DEVELOPMENT HEARING OFFICER
SUPPLEMENTAL SUBMITTAL

PROJECT NO. PR-2022-00710

Application No. SD-2023-00038

**RE: RESPONSE TO DHO COMMENTS MARCH 8TH, 2023
FOR PROPOSED REPLAT TRACT MM-1-B-1 AND TRACT MM-1-B-2 SEVEN BAR RANCH
PR-2022-007100
SD-2023-00038**

Plat of Tracts MM-1-B-1 and MM-1-B-2 Seven-Bar Ranch

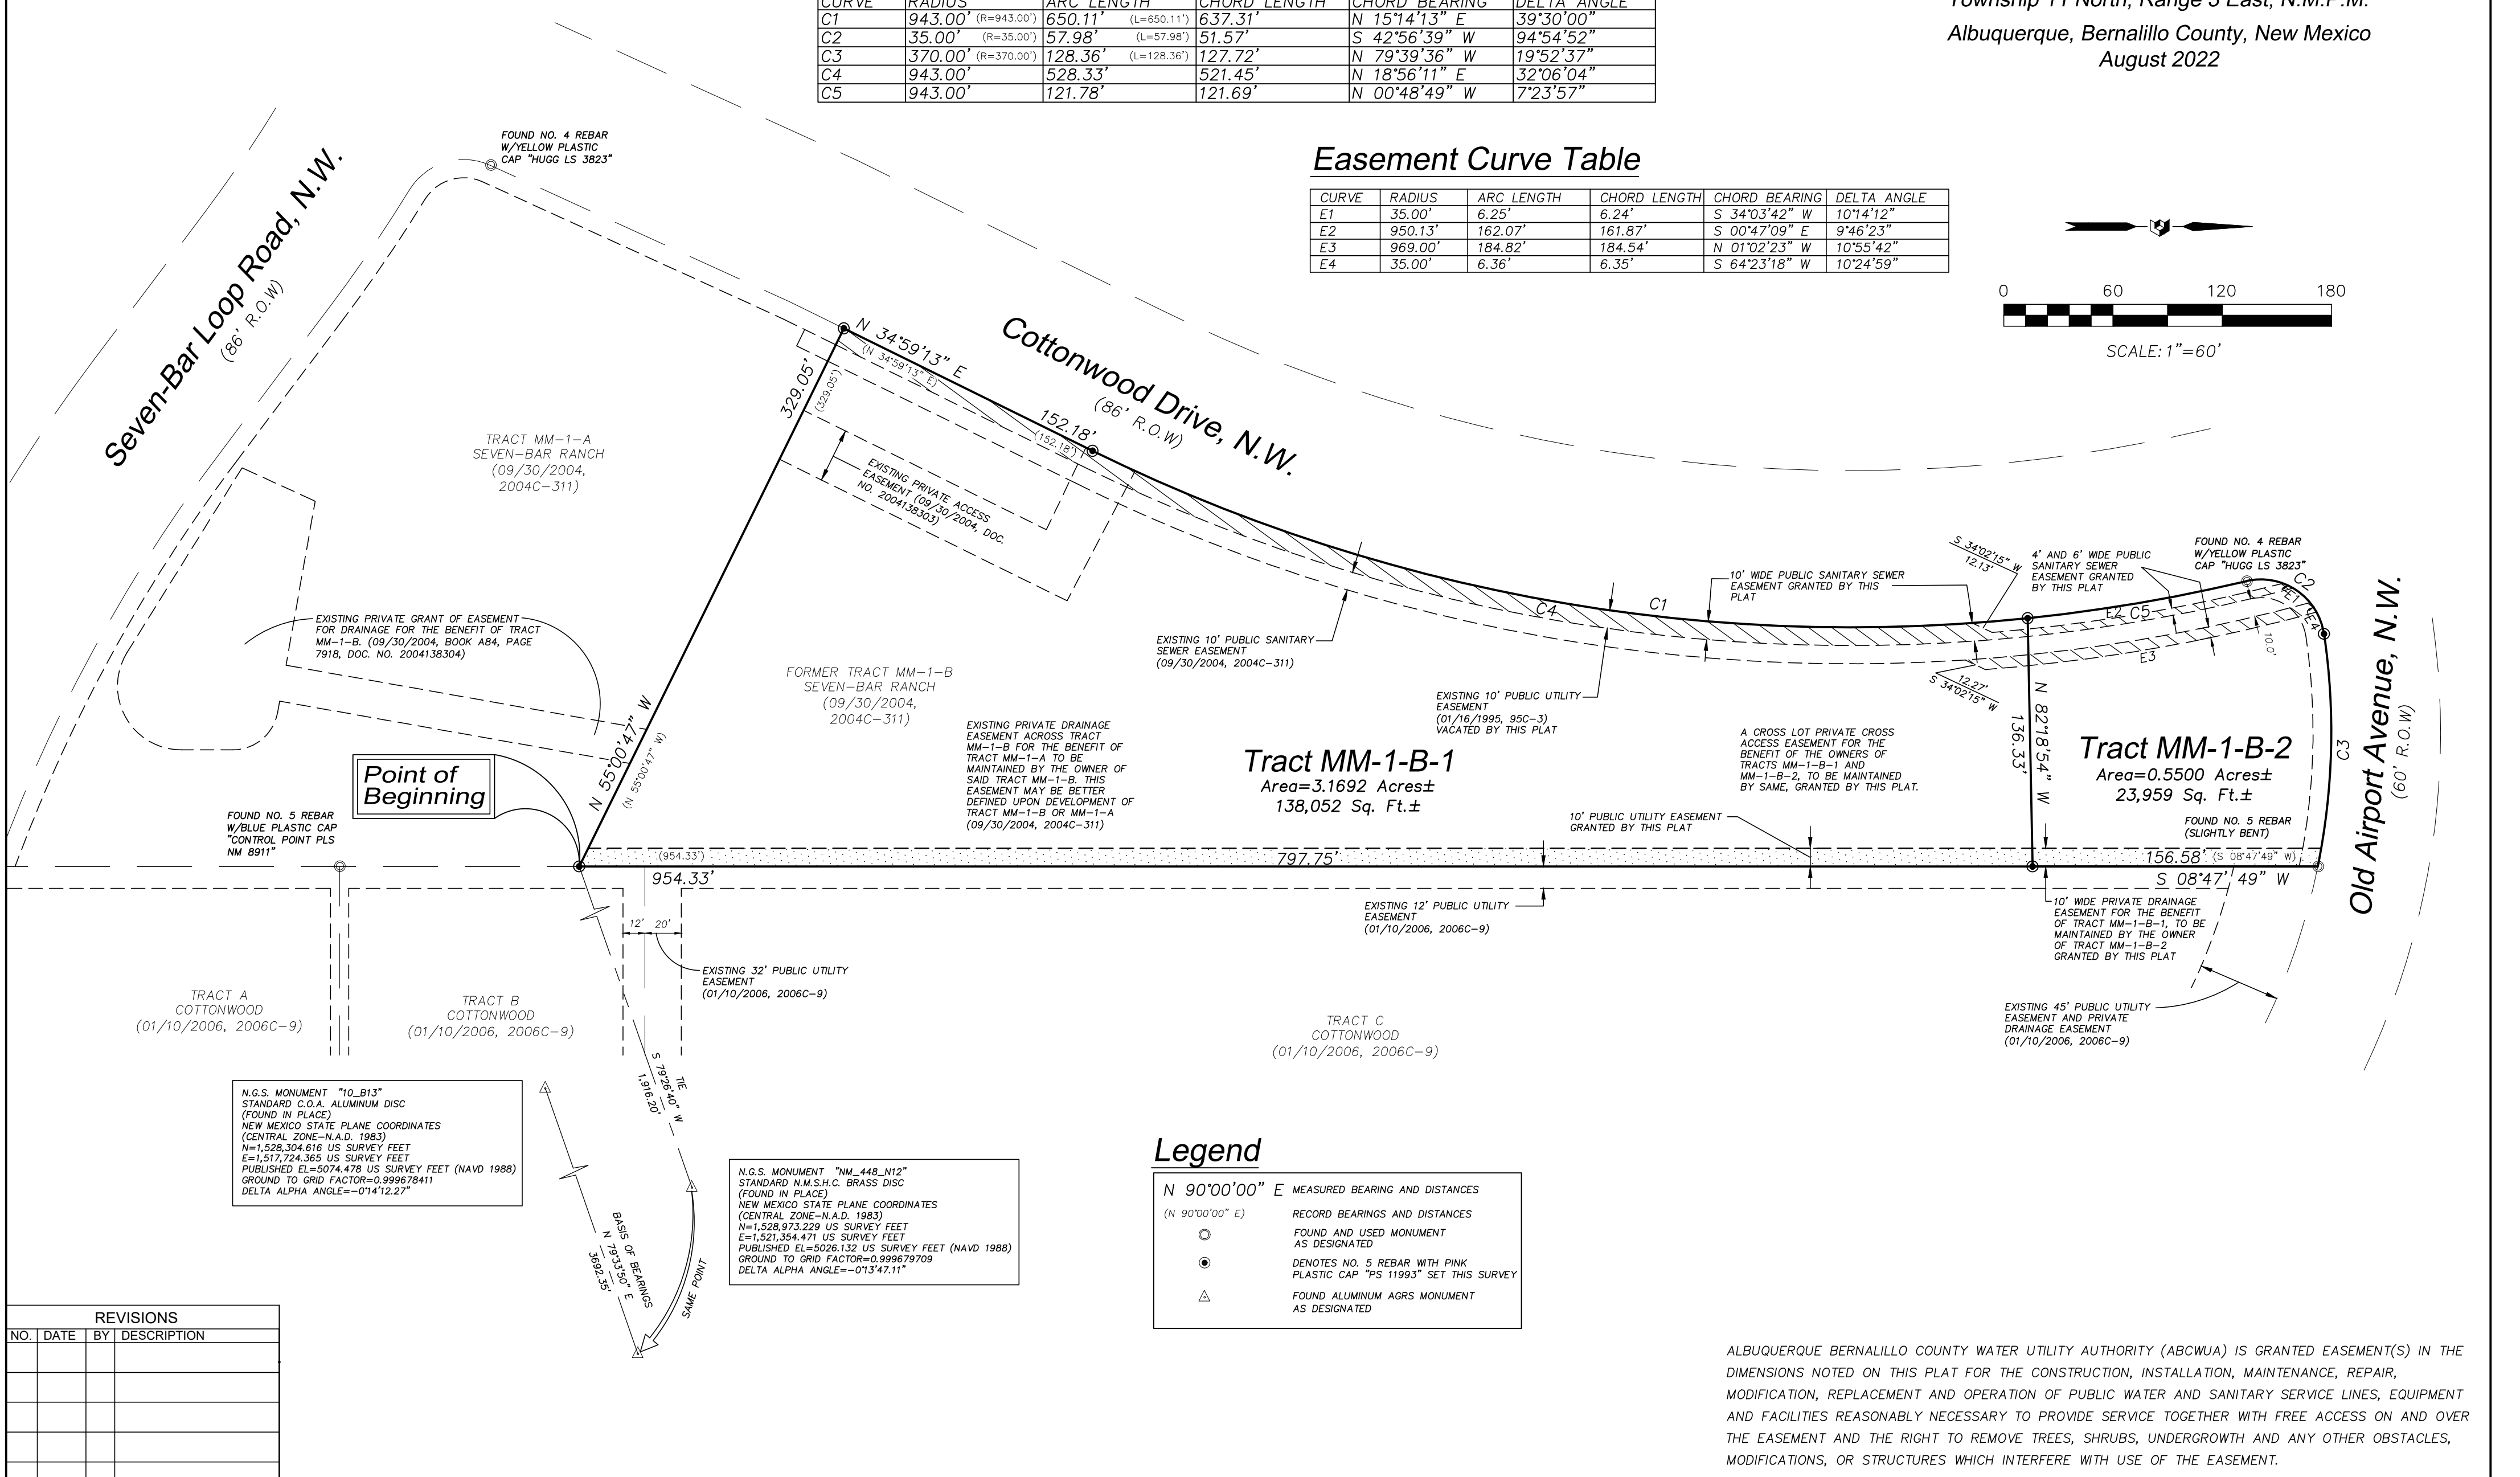
a. The minimum width easement requires is 20'. Please include a 20' easement for the public sanitary sewer line. (Exclusive)

RESPONSE: These comments have been added to the Updated Plat. The Plat is provided with DHO submittal and below.

Plat of  
**Tracts MM-1-B-1 and MM-1-B-2**  
**Seven-Bar Ranch**  
 Town of Alameda Grant, Projected Sections 5 & 8,  
 Township 11 North, Range 3 East, N.M.P.M.  
 Albuquerque, Bernalillo County, New Mexico  
 August 2022

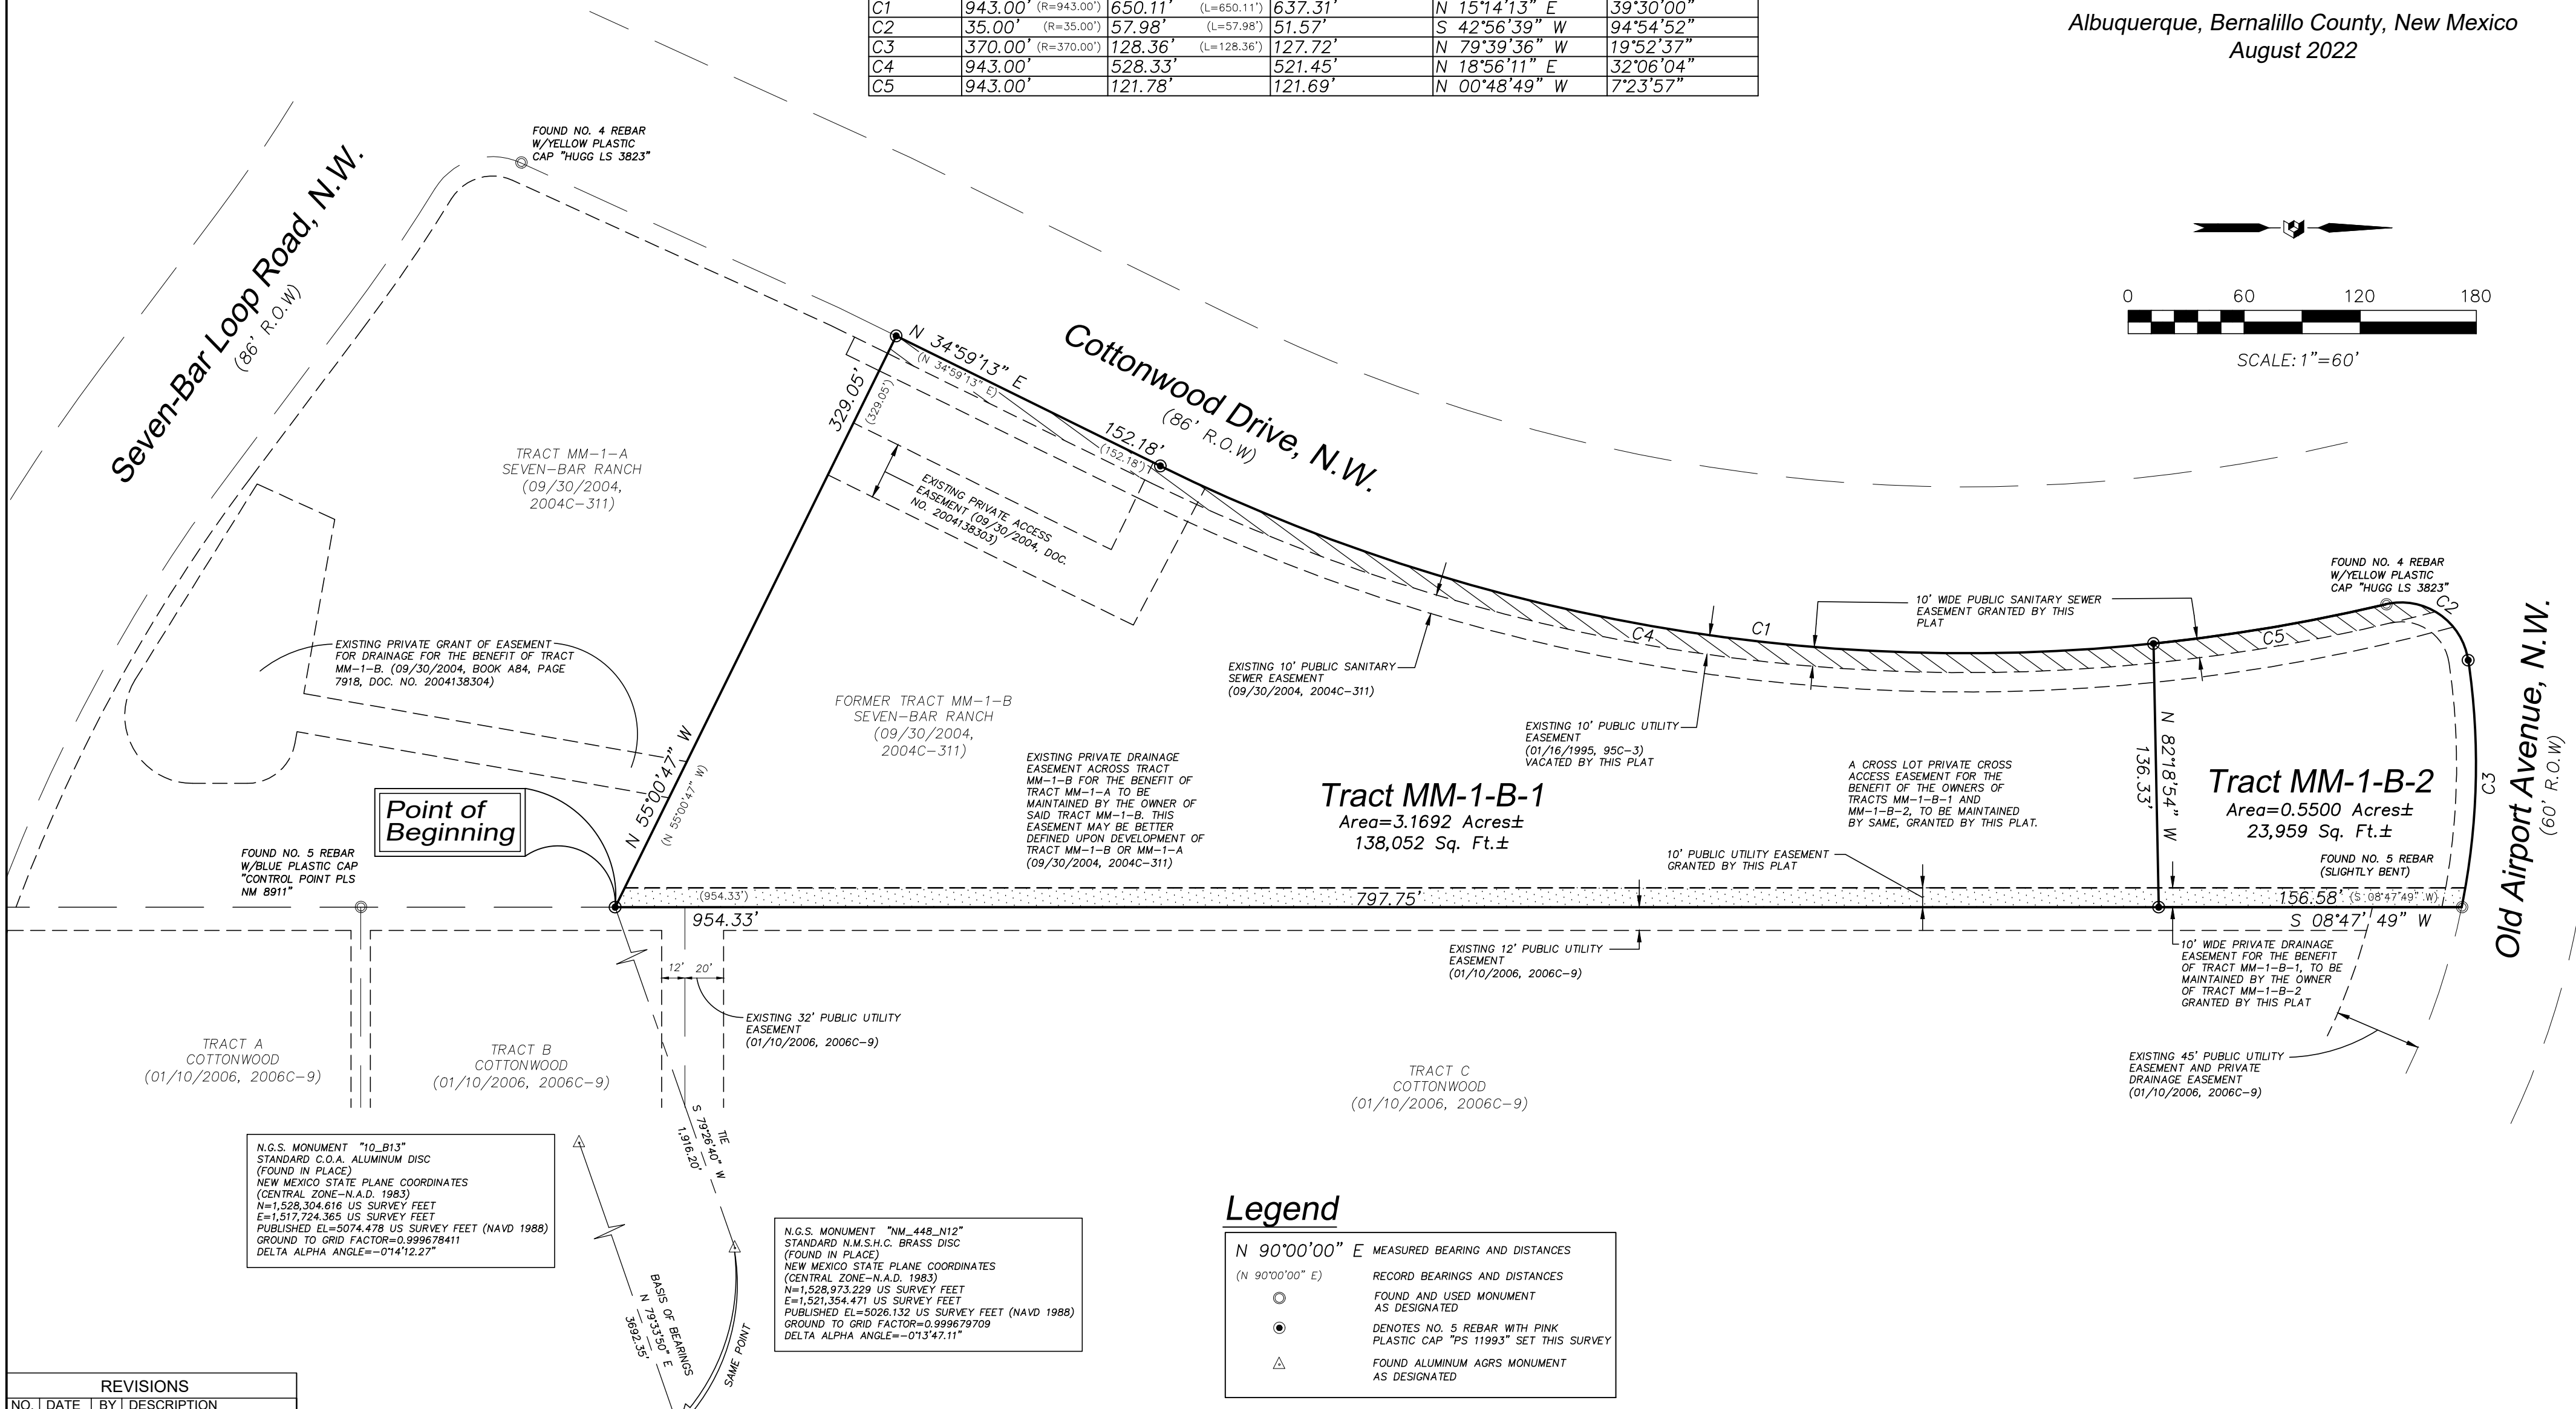
b. Please add the following note

i. ABCWUA Public Water & Sanitary Sewer Easements Albuquerque Bernalillo County Water Utility Authority (ABCWUA) is granted easement(s) in the dimensions noted on this plat for the construction, installation, maintenance, repair, modification, replacement and operation of public water and sanitary service lines, equipment and facilities reasonably necessary to provide service together with free access on and over the easement and the right to remove trees, shrubs, undergrowth and any other obstacles, modifications, or structures which interfere with use of the easement.

4. Incorporate shared access with neighboring property as needed, and radius for entry drive off of roadway should not encroach into neighboring property.

RESPONSE: This has been added to the Plat. The Plat is provided with DHO submittal and below.
